Recommendation Report for Planning Permission

REF NO: R/282/21/PL

LOCATION: 34 The Crescent
Rustington
BN16 2PF

PROPOSAL: Variation of condition imposed under R/25/21/HH relating to condition 2-plans condition. This is a Householder Application.

DRAWING: 2120/05 REVISION:

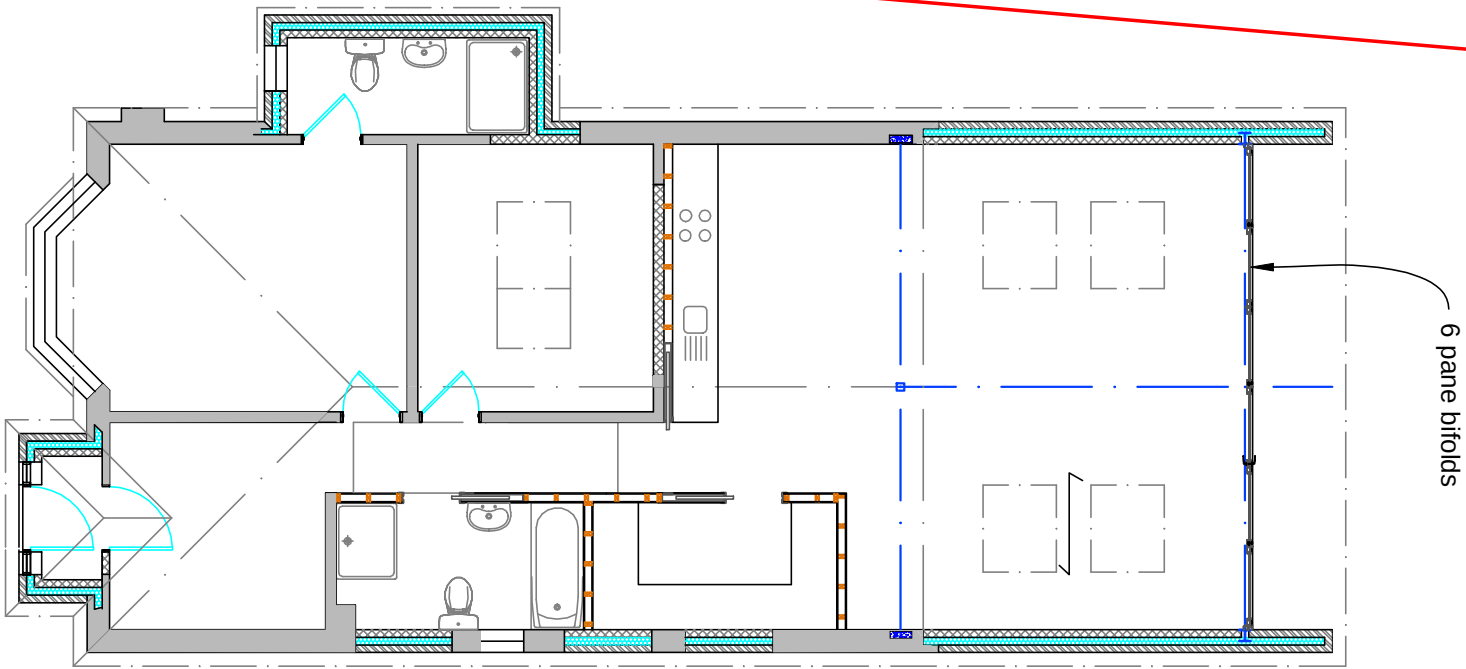
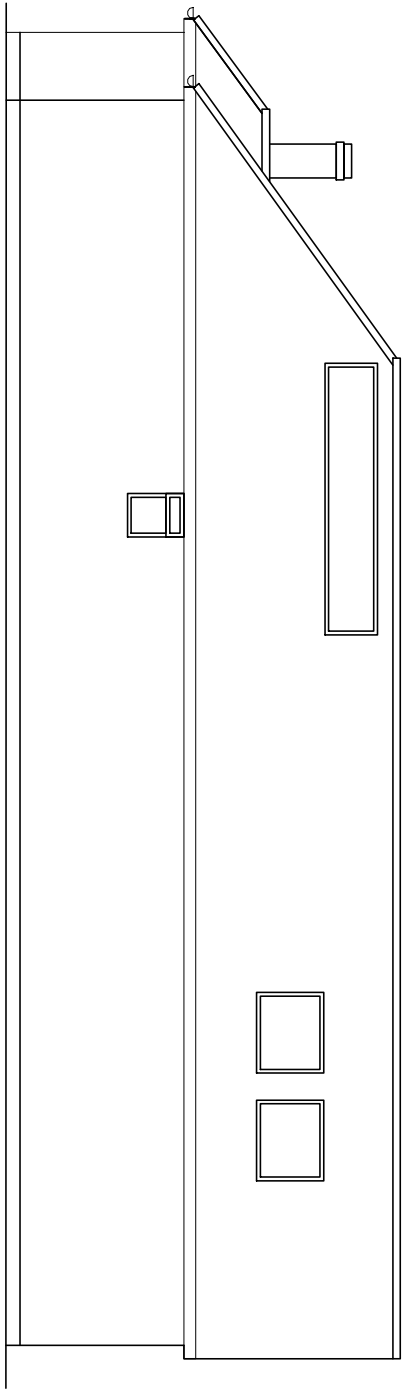
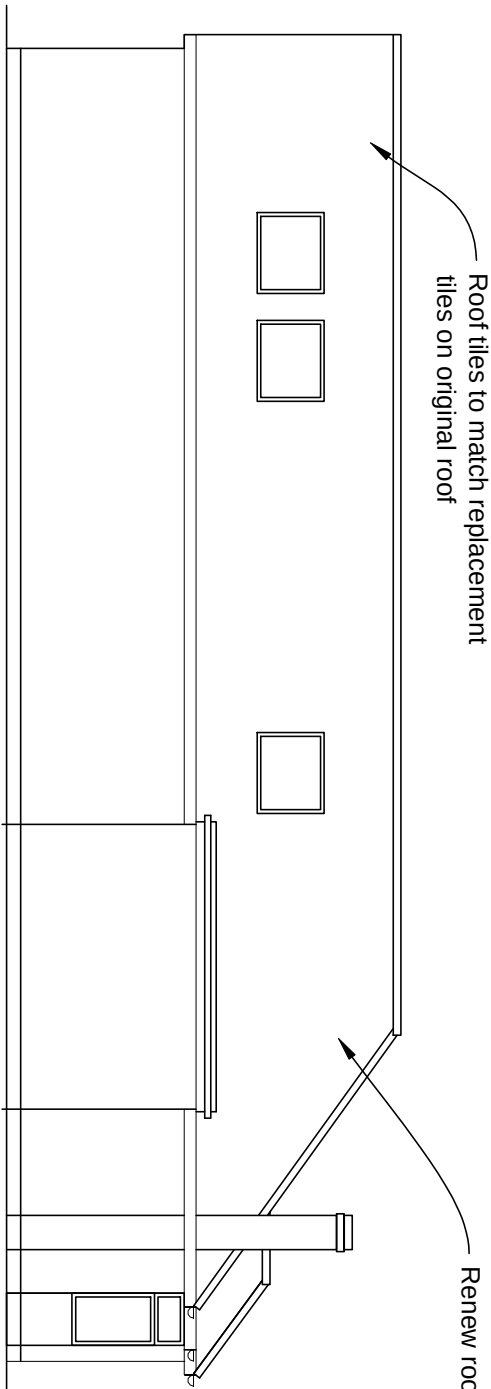
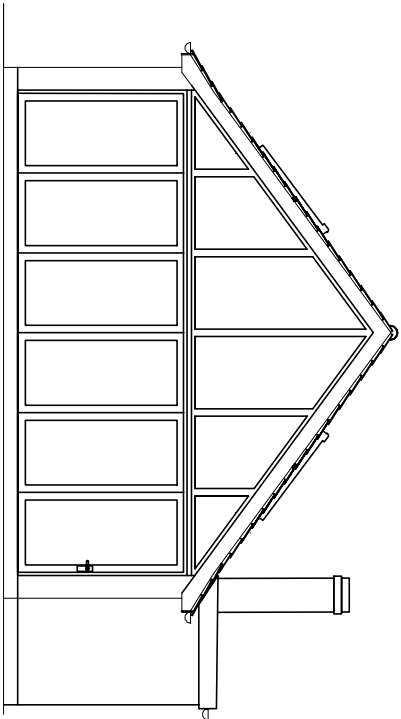
The principle of the development has been agreed. It is only the issues relating to the amended plans which can be considered. This application seeks to alter the choice of roof covering and alterations to the approved fenestration of the as built project.

The alterations to the roof finish are acceptable by reason that they appear visually integrated with the property and the wider street scene and the upgrade to the existing roof tile, which has a similar colour and appearance to that of the neighbour to the southwest, is deemed subservient to the host dwelling.

The amendments to the openings such as the alteration to the number of leaves to the bi-fold door, the omission of the window to the pantry and utilisation of the existing window to the bathroom, and the blocking up of the existing southwestern facing side window are subservient to the host dwelling and do not compromise the visual integration of the works.

The proposed alterations to the openings of the proposal will not negatively impact overlooking of adjoining properties and in some case will improve the situation.
